Sheringham Shoal and Dudgeon Offshore Wind Farm Extension Projects

The Applicant's Response to the Maritime and
Coastguard Agency's Deadline 3 Submission

Revision A
Deadline 4
May 2023
Document Reference: 18.6

Title:	
Sheringham Shoal and Dudgeon Offshore Wind Farm Extension Projects Examination submission The Applicant's Response to the Maritime and Coastguard Agency's Deadline 3 Submissions	
PINS document no.: 18.6	
Document no.: C282-AN-Z-GA-00009	
Date:	Classification
May 2023	Final
Prepared by:	
Royal HaskoningDHV	
Approved by:	Date:
Tom Morris, Equinor	May 2023

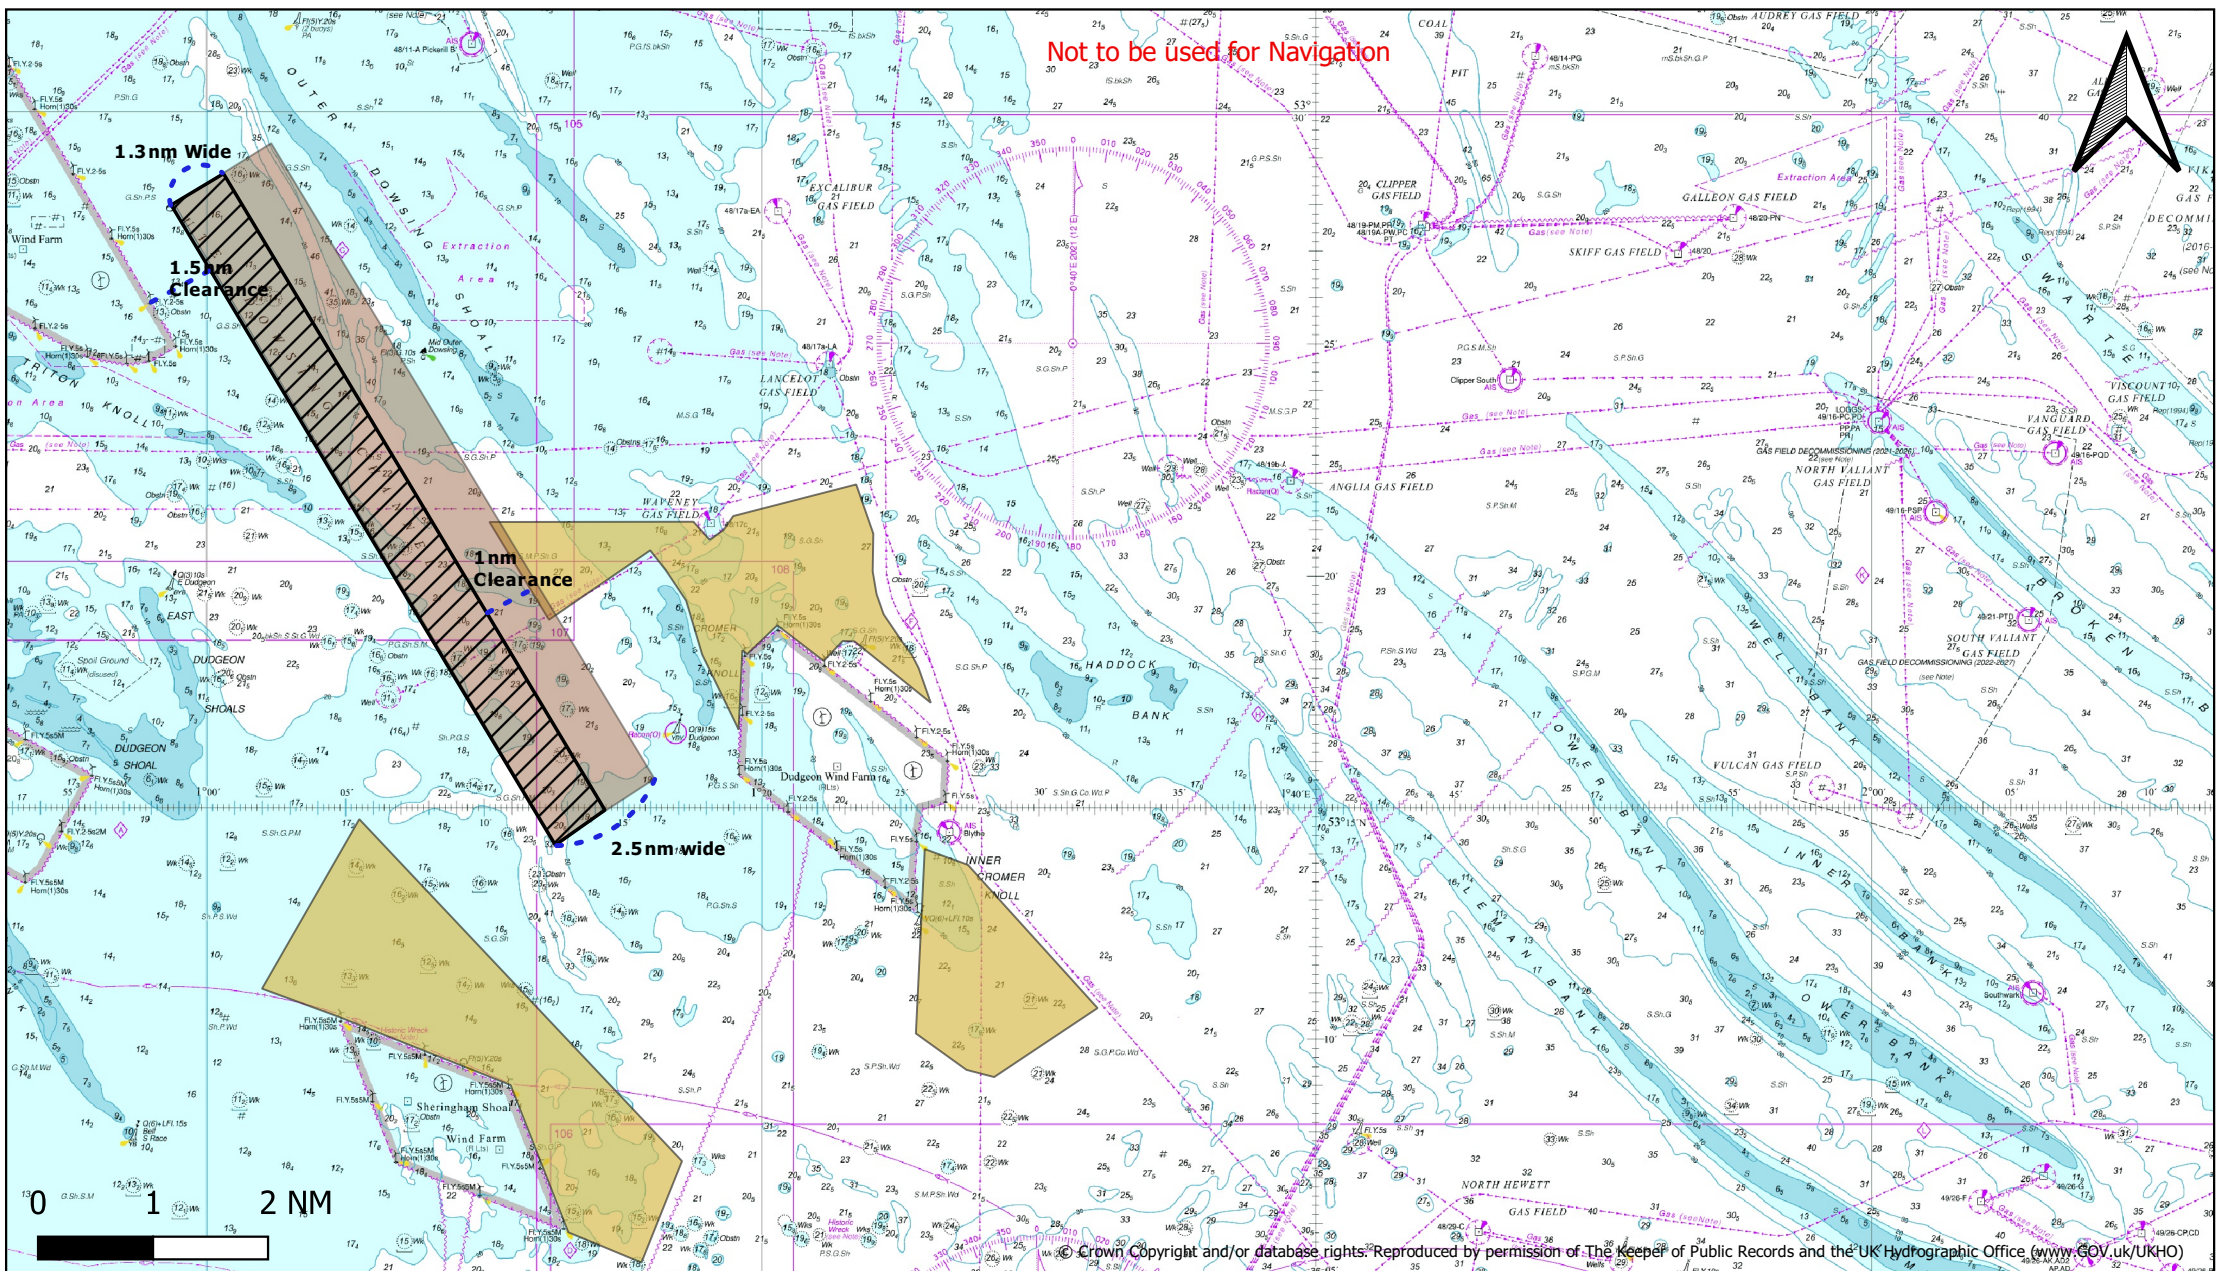
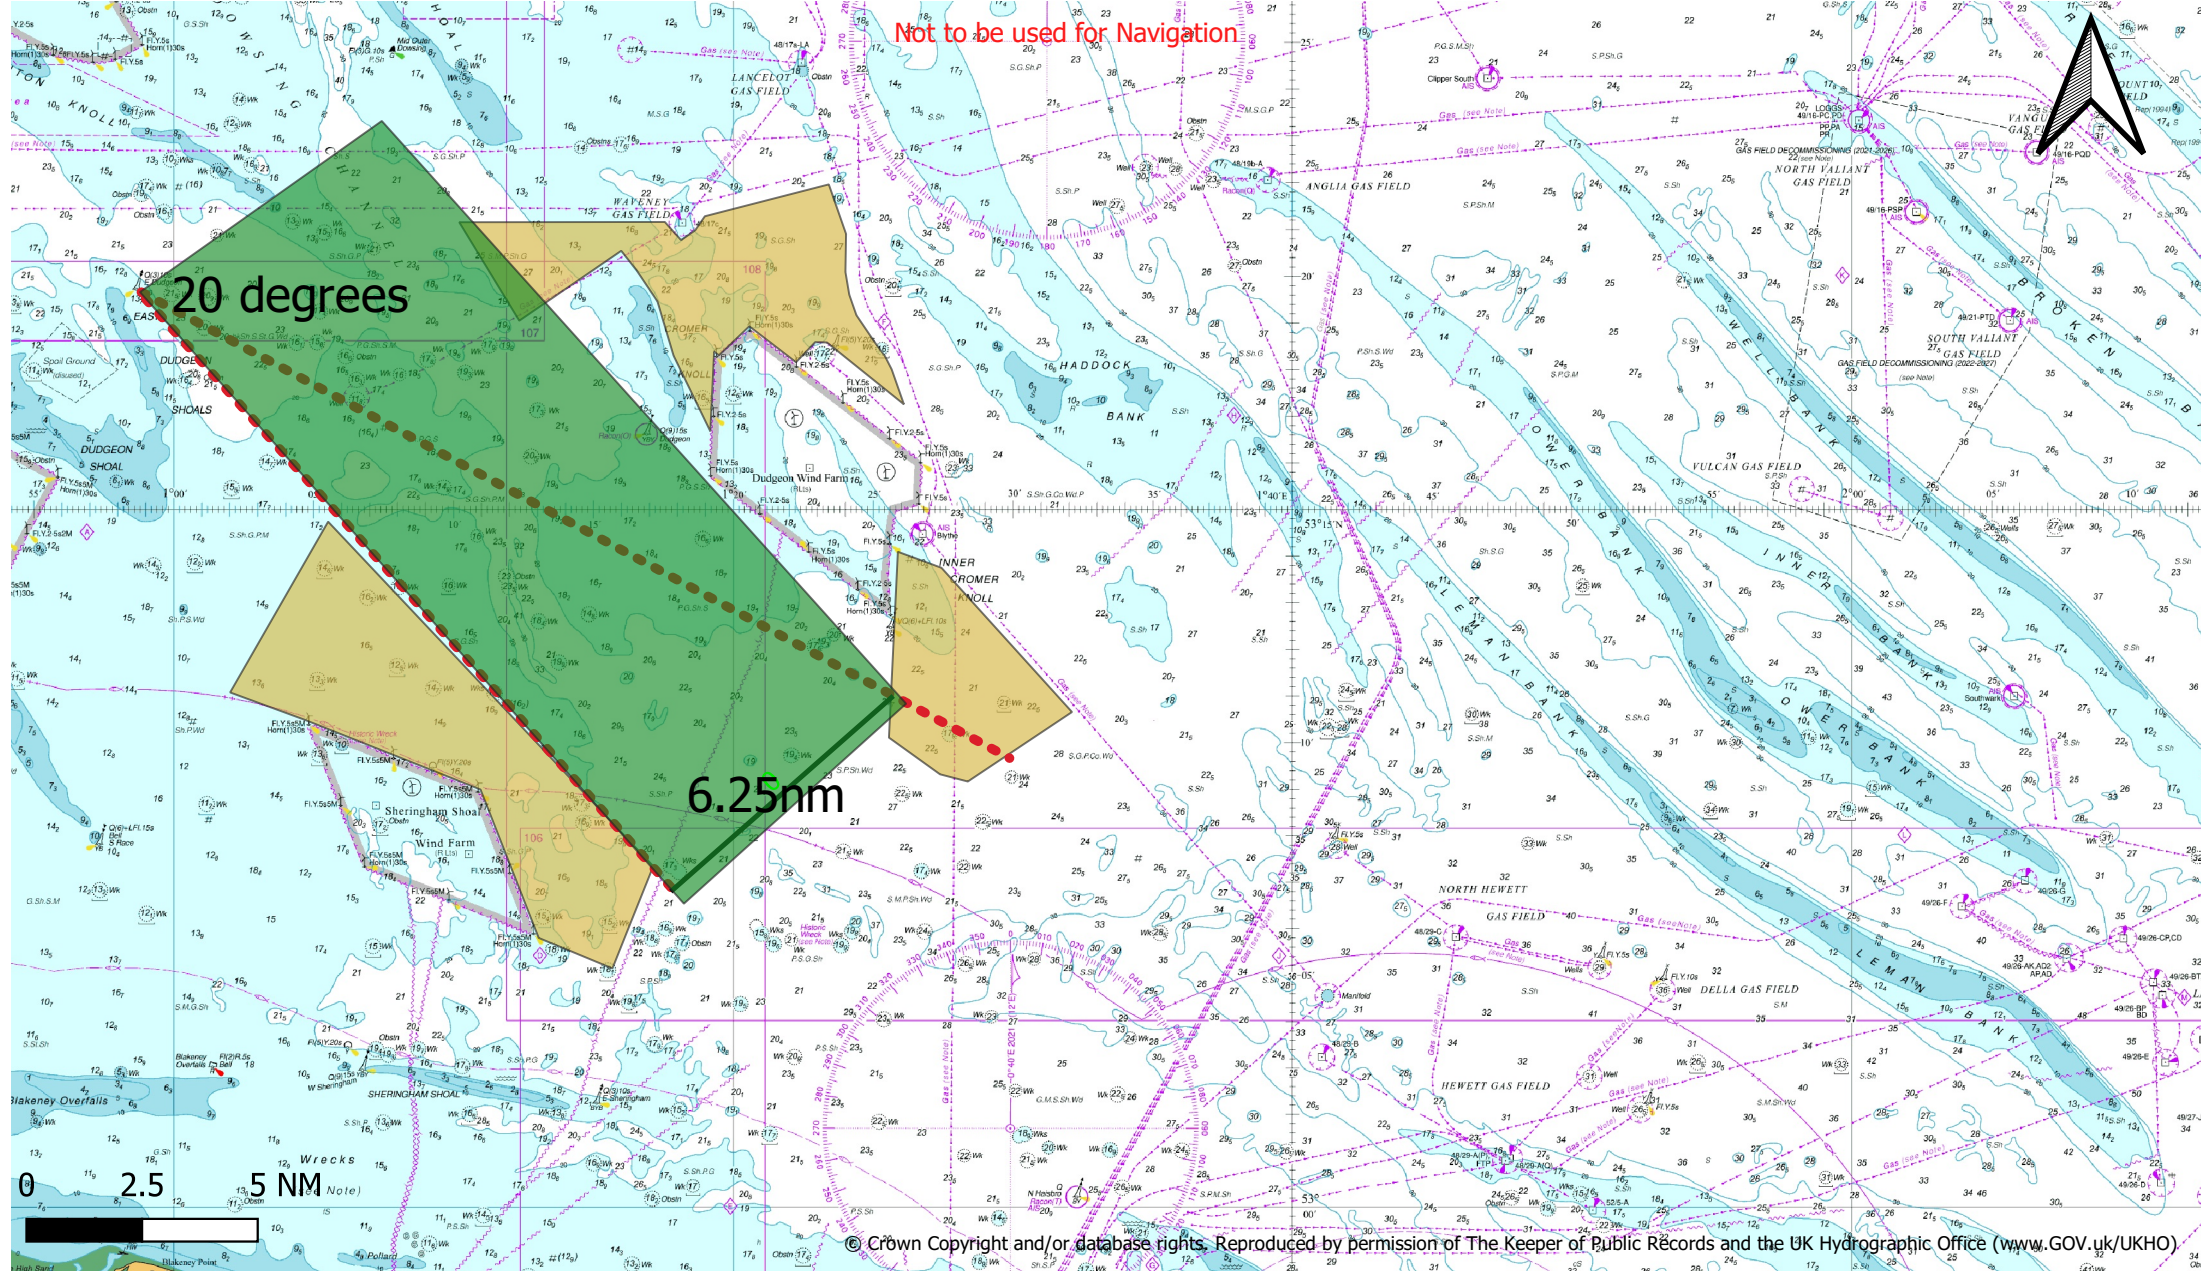
ID	MCA's Written Representation	Applicant comments	MCA response	Applicant's response
	<p>Commercial vessels will typically ensure a safety buffer of at least 1NM between their course and an offshore wind farm boundary and the traffic study shows this is 1.5NM. 90% of this traffic transits in a 'corridor' 5.5NM wide and the introduction of the two extension projects will reduce this corridor to 3.6NM of sea room; a reduction of sea room of 34%.</p>

1.3	<p>In Fig 18.1 of the NRA the 20% corridor guidance from MGN 654 has been used to show the minimum width required for the 11.2NM long corridor between the extensions should be at least 4.1NM. The boundaries at the narrowest point are 5.6NM apart, however it is noted that shallow banks marked by the East Dudgeon buoy potentially extend the</p>	<p>The NRA [APP-198] included application of the MCA methodology for corridor width calculation set out in MGN 654, with the strict interpretation of the width requirements being found to be met. In line with the MGN 654 wording, the calculation was based on the area "where turbines appear along both sides of a shipping corridor". It is acknowledged that strict application of the calculation does not account for the presence of the local shallow banks, and text on this basis was included in Section 18.4 of the NRA [APP-198].</p>	<p>The corridor guidance in MGN654 is to be used for determining safe distances between wind farms boundaries and shipping routes on a case-by-case basis. Factors that should be considered, in addition to the 20-degree model, are described in Section 4.7 in MGN654. It is important to recognise that the corridor guidance and shipping route template are not prescriptive tools but need intelligent application.</p>	<p>As per the latest Draft Statement of Common Ground Maritime and Coastguard Agency [REP3-079], the Applicant and MCA are now in agreement on the corridor width between SEP and DEP (i.e., where bounded on both sides by turbines).</p>

ID	MCA's Written Representation	Applicant comments	MCA response	Applicant's response
	<p>corridor length a further 6.5NM to the northwest since there is no safe sea room to the west of a line between the East Dudgeon buoy and the northern corner of the Sheringham Shoal Extension boundary. As such, is it arguable the length of the corridor would be 17.2NM and the required width as per the guidance in MGN 654 should be at least 6.25NM.</p>
